Re: Chase Bank - Eubank
340 Eubank Blvd NE
Traffic Circulation Layout
Architect's Stamp None provided (K21-D009C)

Based upon the information provided in your submittal received 08-20-2020, the above referenced plan cannot be approved for Building Permit until the following comments are addressed:

**TRAFFIC CIRCULATION PLAN**

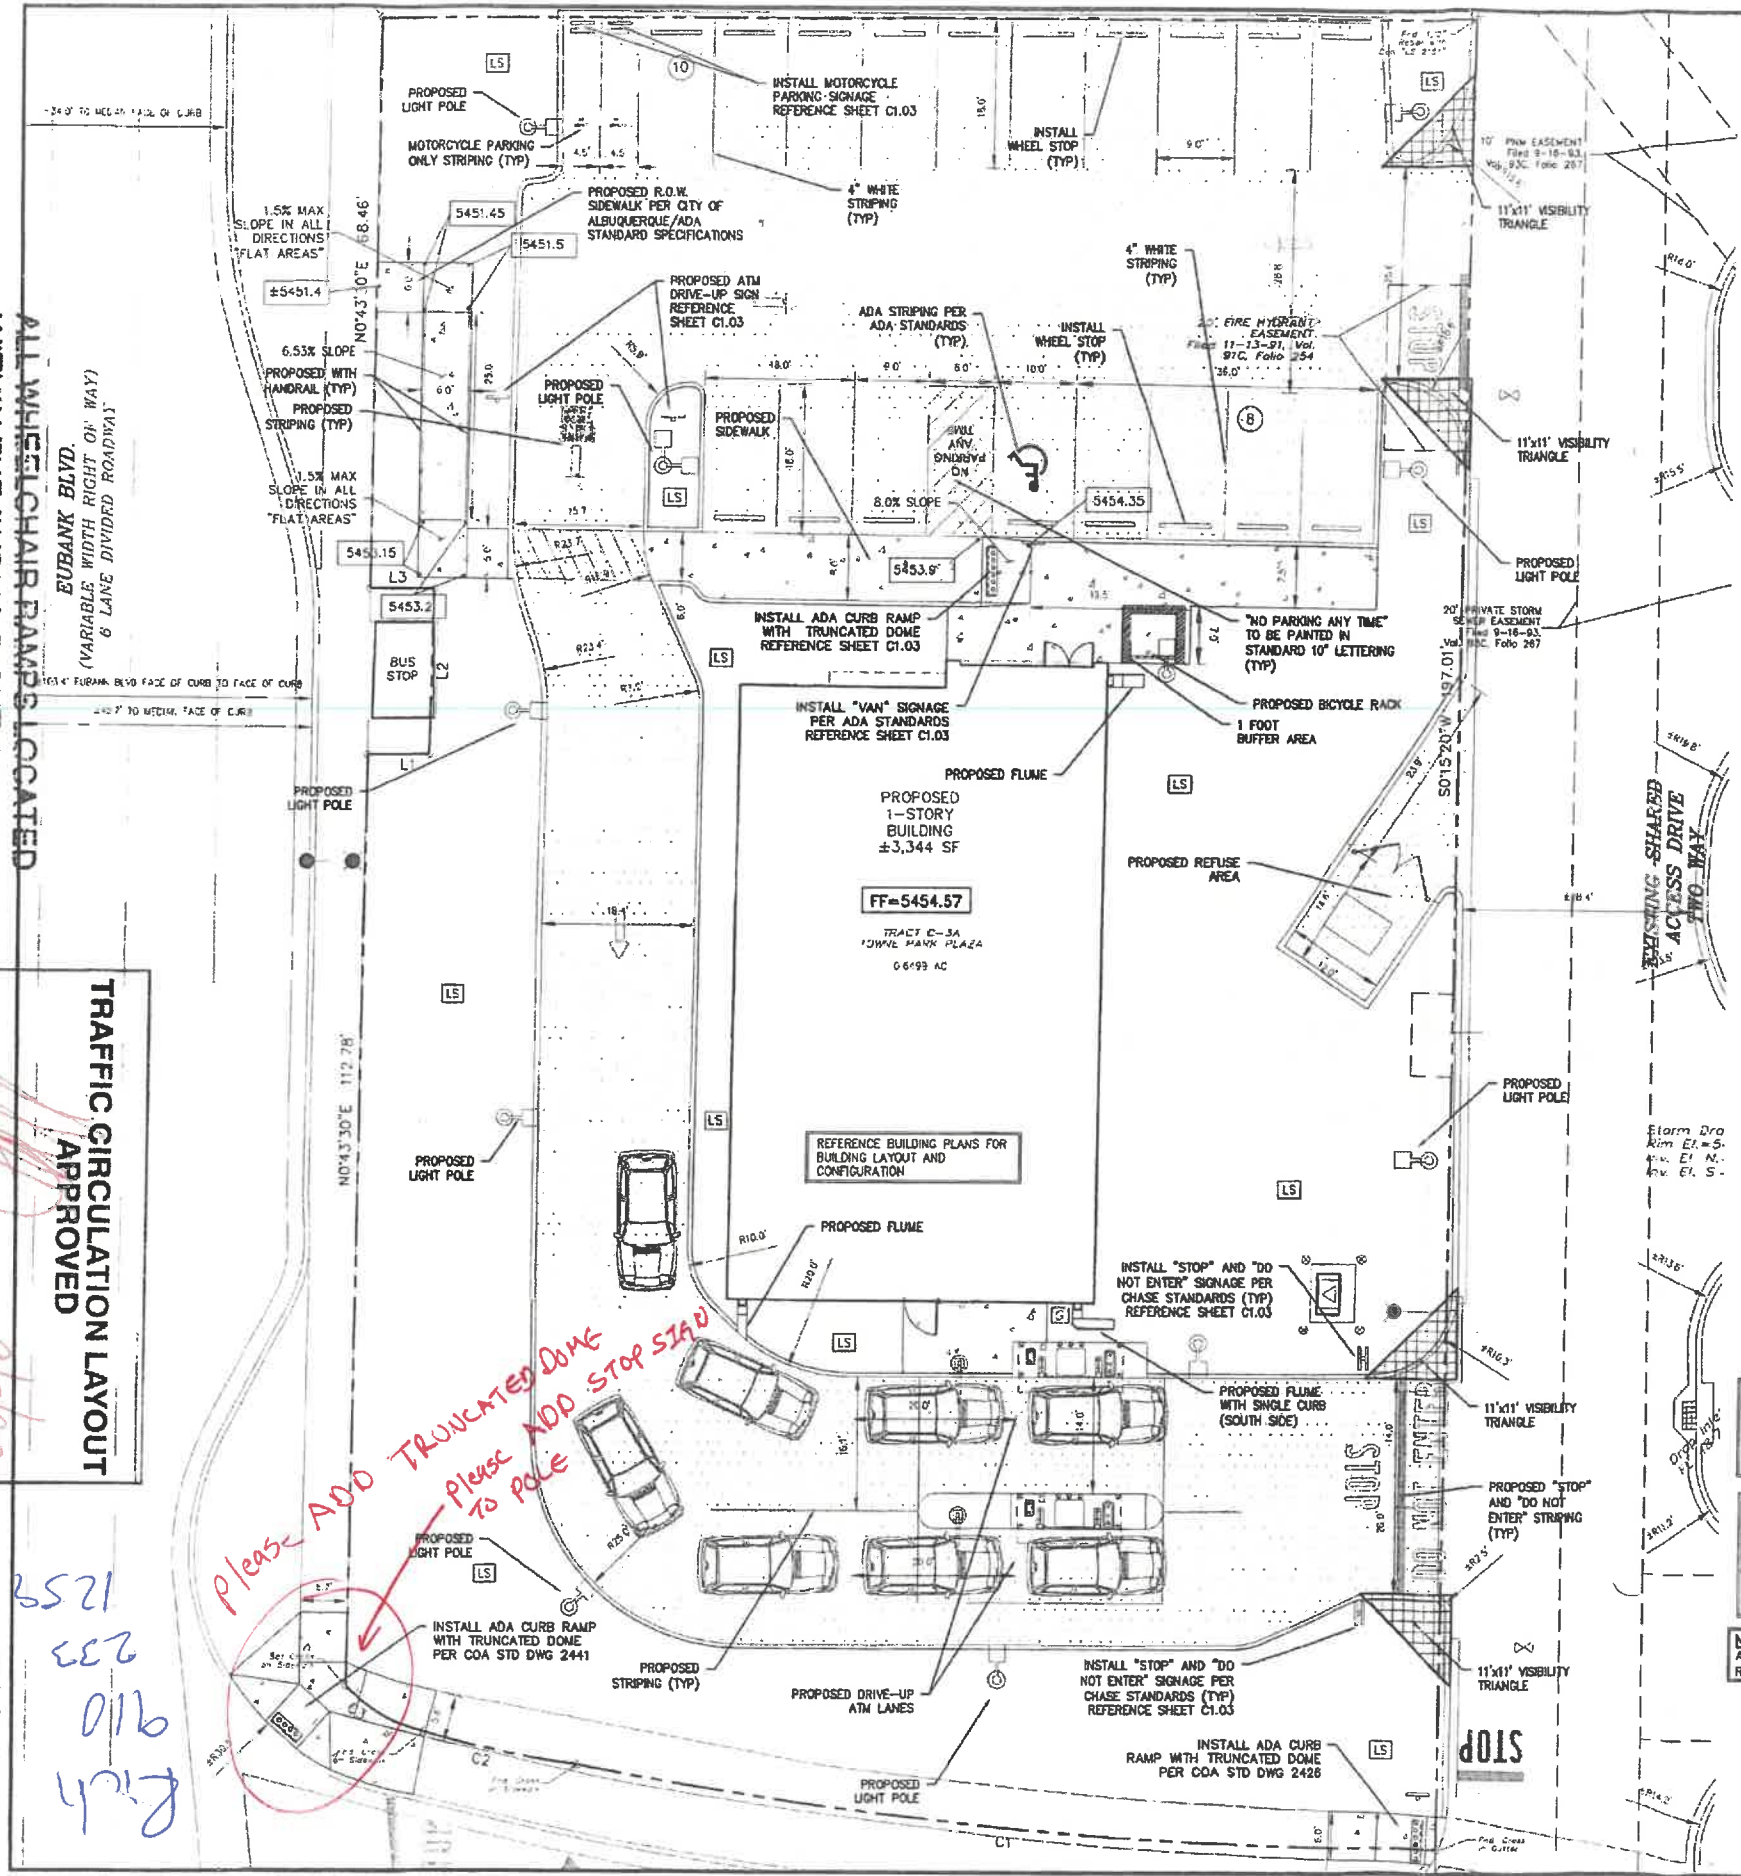
1. The TCL (traffic circulation layout) must be stamped, signed, and dated by an engineer or architect licensed in the state of New Mexico.
2. ADA curb ramps must be updated to current standards and have **truncated domes installed**. There are two ramps on public and private easement that also need to have truncated domes. They are located at the south eastern corner of the property and the south western corner of the property.

3. Provide ADA curb ramp detail since COA doesn't have ramp detail that fits parking stalls:
 - Ramp slopes: **8.33% max**. Adjust your proposed parking stall ramp .

- You have provided railings to define the slope of the ramp. Please either provide a detail of ADA railing.
4. Motorcycle parking spaces Label pavement MC (only).

7. Please provide Sign Post detail for all proposed signage.
8. City sidewalk detail is under **COA std dwg 2430**. Please add this verbage to plans.
9. Show the clear sight triangle and **add the following note to the plan:**
"Landscaping and signage will not interfere with clear sight requirements. Therefore, signs, walls, trees, and shrubbery **between 3 and 8 feet tall** (as measured from the gutter pan) will not be acceptable in the clear sight triangle.

10. **Add a note stating** "All broken or cracked sidewalk must be replaced with sidewalk and curb & gutter." **A build note must be provided referring to the appropriate City Standard drawing (2430 & 2415).**
